# **FENWICK SOLAR FARM**

**Applicants Response to Examining Authority's Second Written  
Questions (ExQ2)**

**Document Reference: EN010152/APP/8.35**

July 2025  
Revision Number: 00

Figure 8-5-2

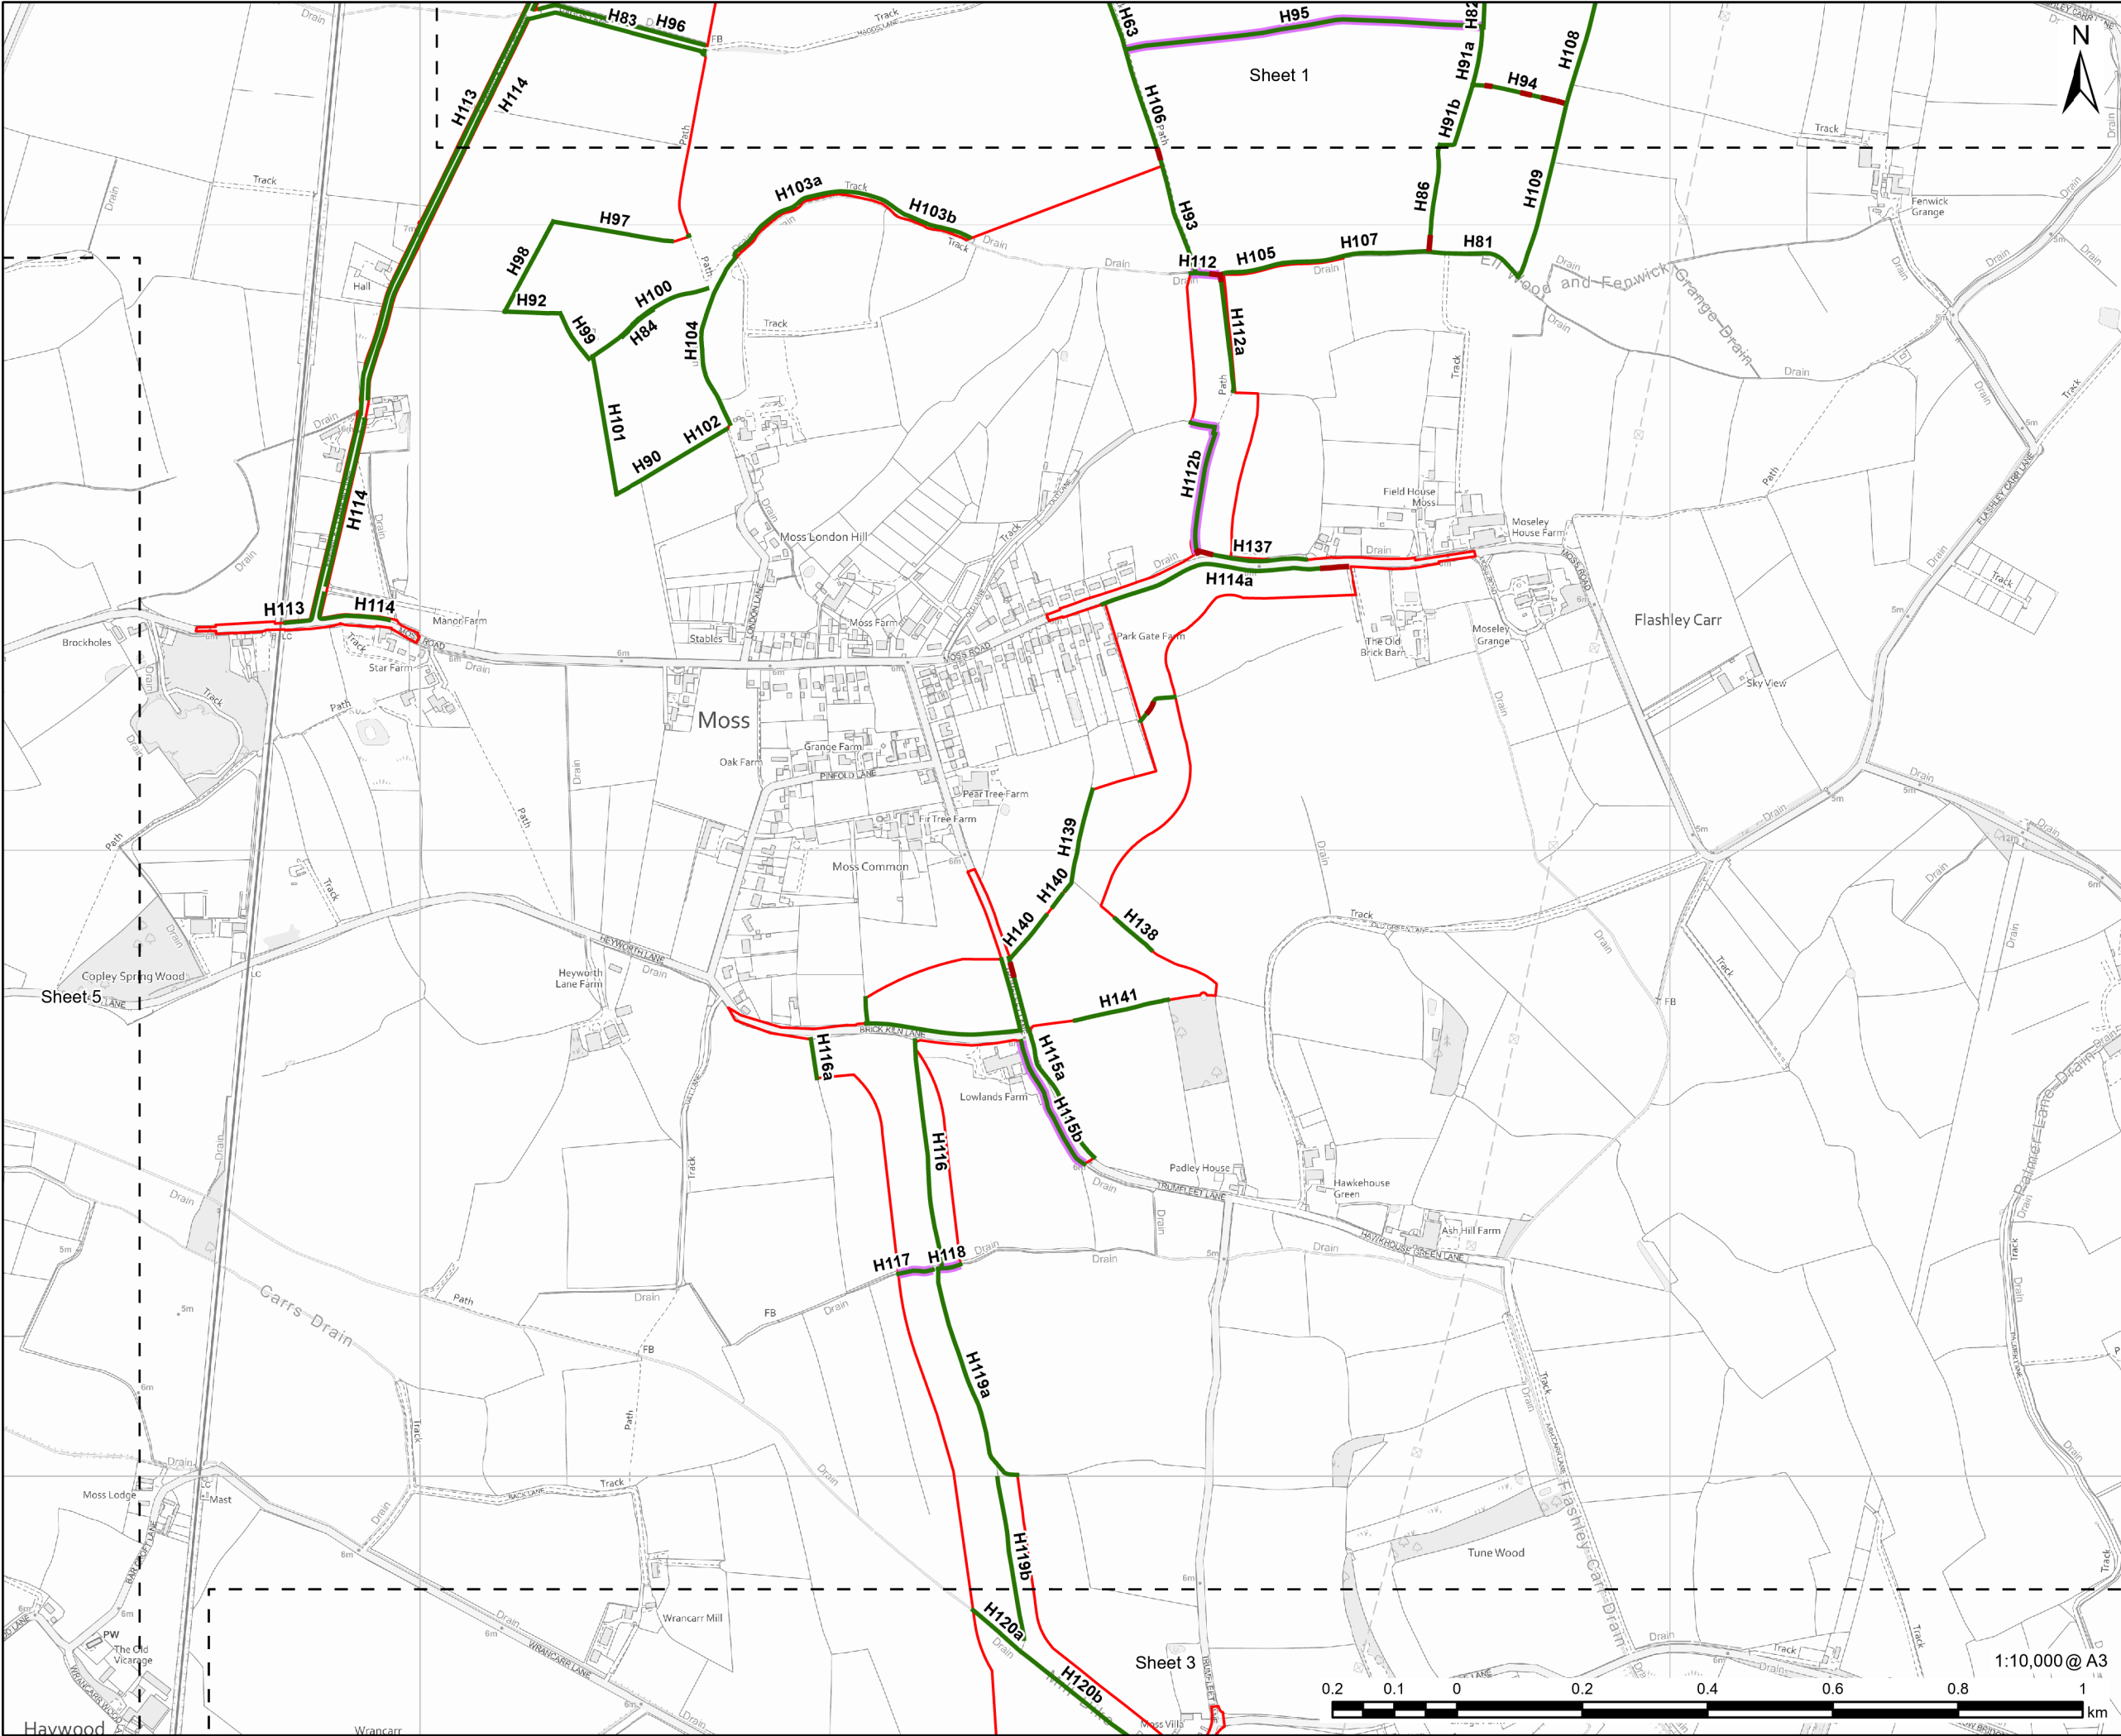
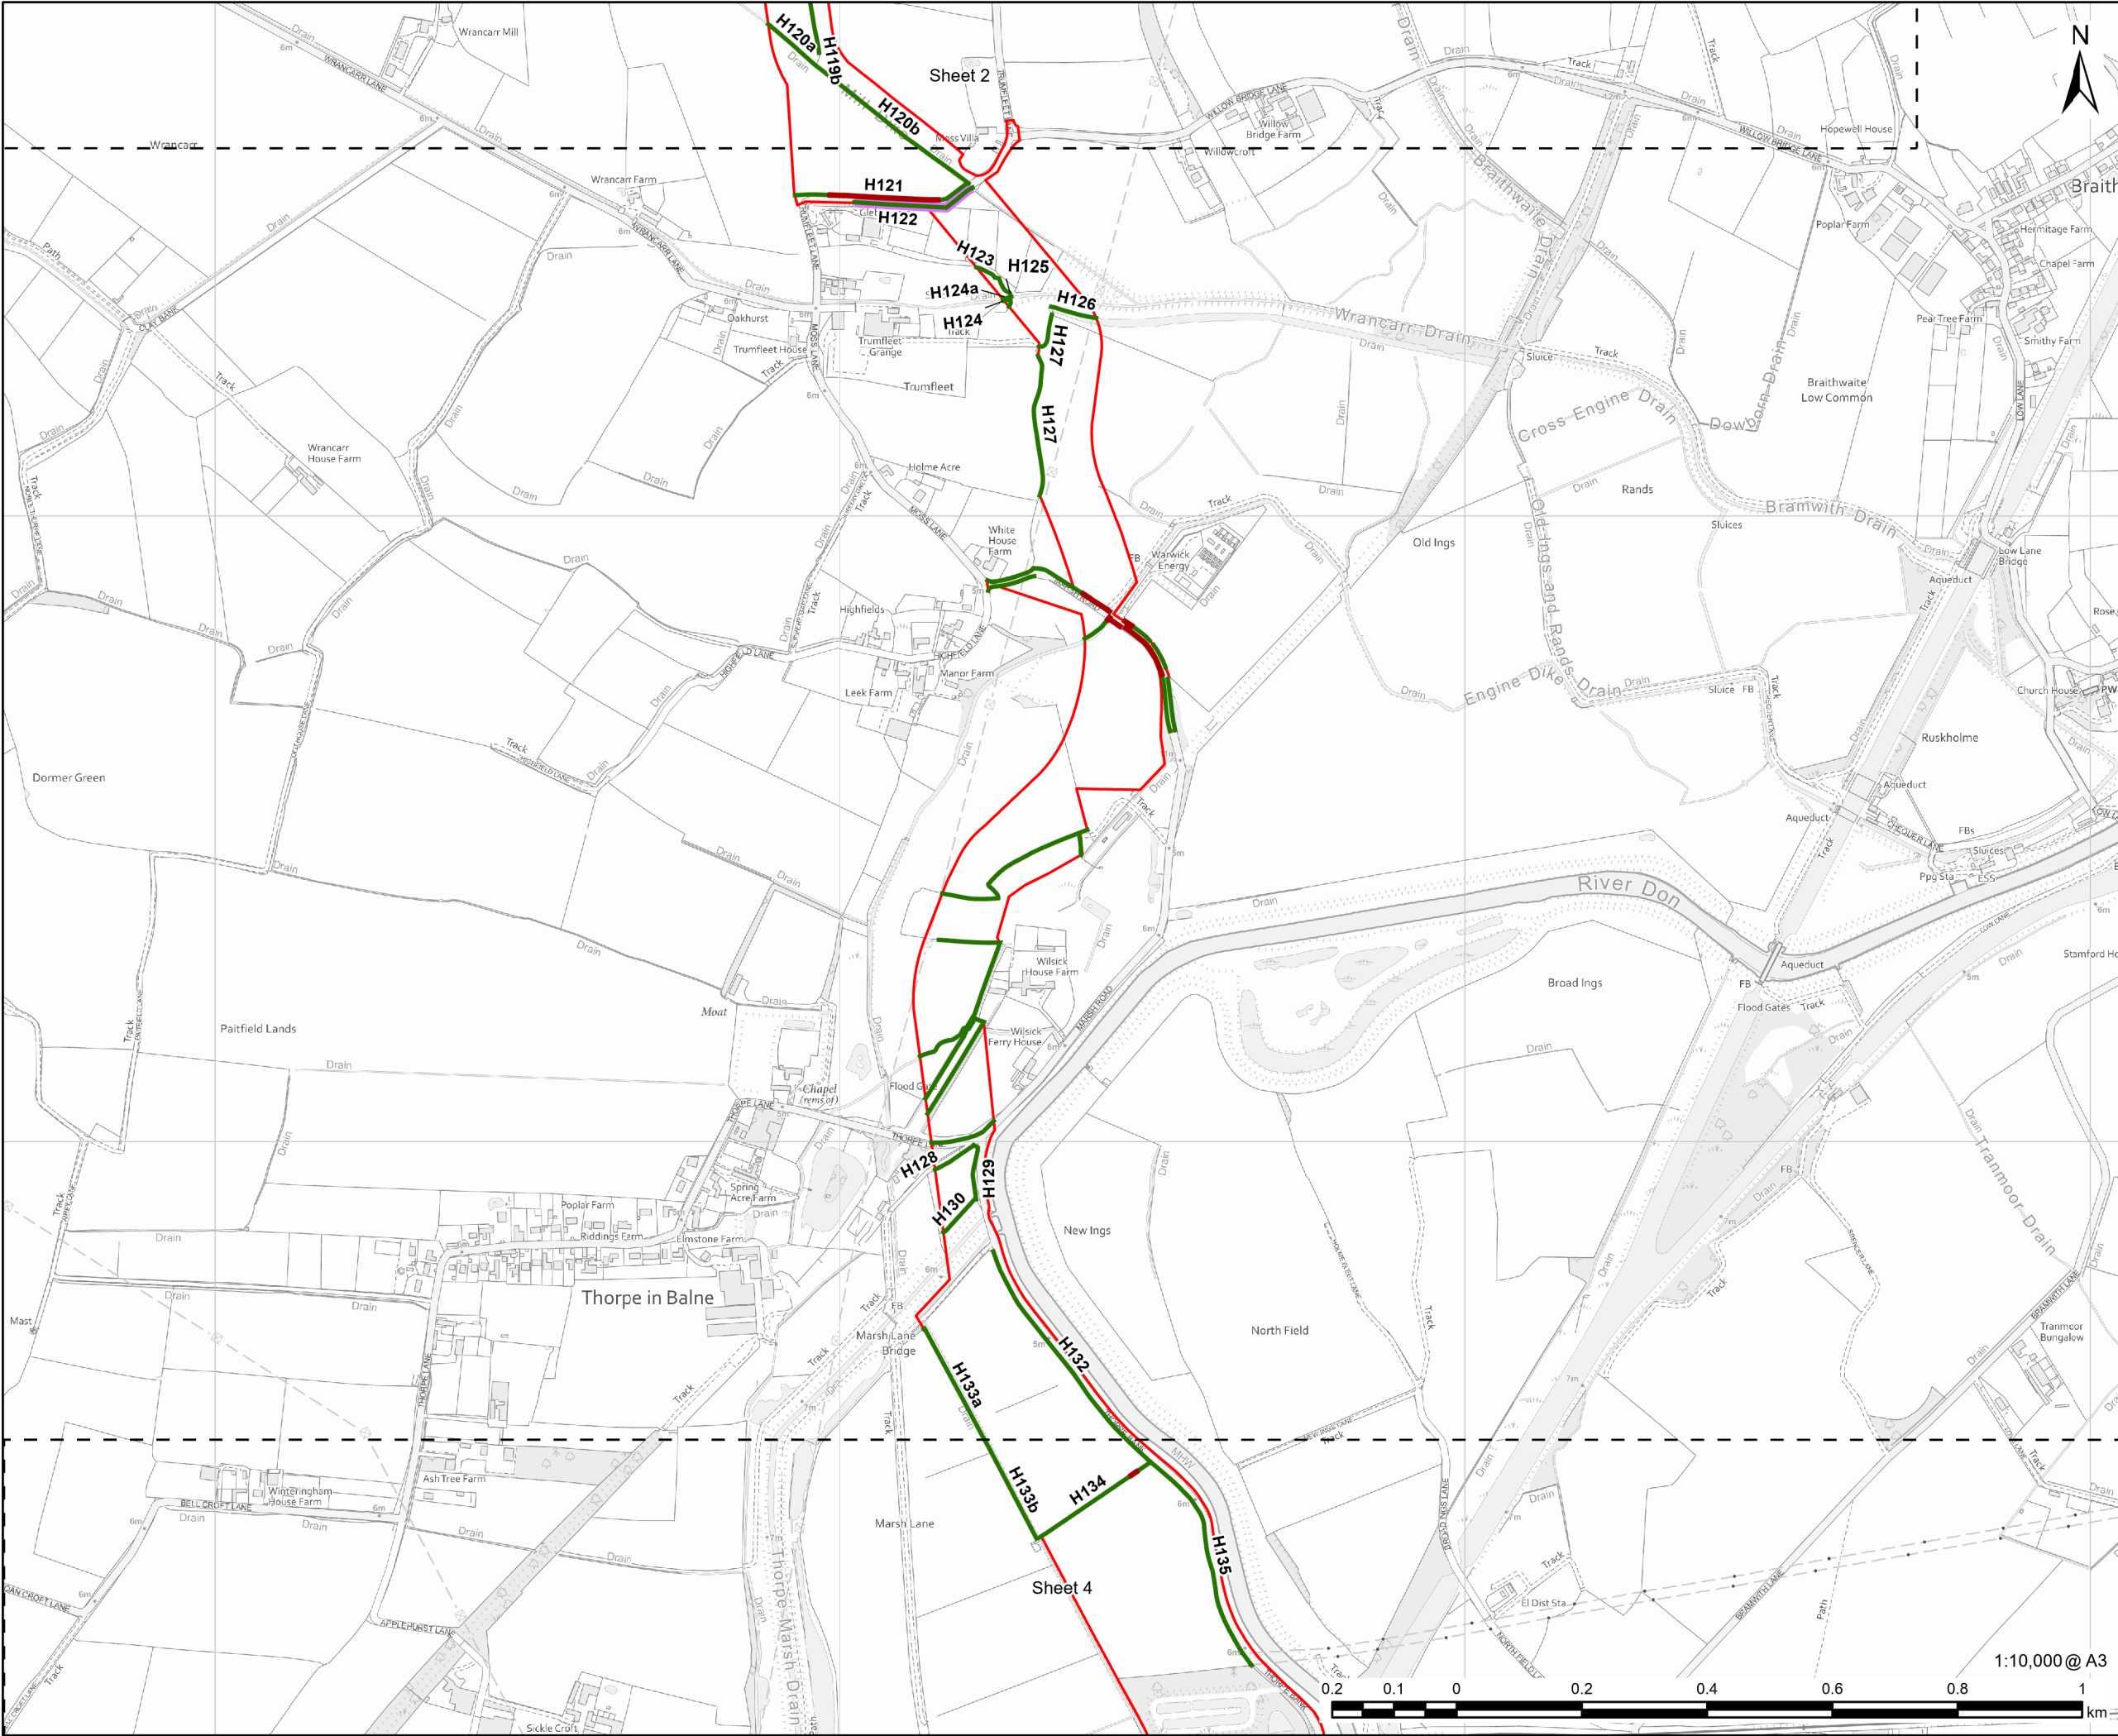
1.6.11	Applicant	Figure 8-5-2 of the Hedgerow Report [REP3-010]. Hedgerow 94 appears to have multiple sections removed as shown on figure 8-5-2 totalling approximately 77.5m in length which is approximately 53% of that total hedgerow. There is also proposed to be gapping up of this hedgerow. Please explain whether the hedgerow removal for H94 is temporary for the construction phase or the duration of the operation and in which case, how will gapping up align with this. Why is this called "N/A defunct" in table 2 under the heading "Important hedgerow Y/N".	Hedgerow 94 is labelled as 'N/A defunct' in Table 2 of <b>ES Volume III, Appendix 8-5: Hedgerow Report [REP3-010]</b> because there are substantial gaps along the length of the hedgerow, meaning it is essentially defunct as a hedgerow. As such, it has not been possible to complete the other scoring criteria in Table 2. The areas shown in red as hedgerow removal more accurately reflect where the existing gaps are located. As such, this does not (in reality) reflect loss of sections of a hedgerow. Access through Hedgerow 94 will be for the construction phase only, so gapping up along Hedgerow 94 will be possible once construction is complete.
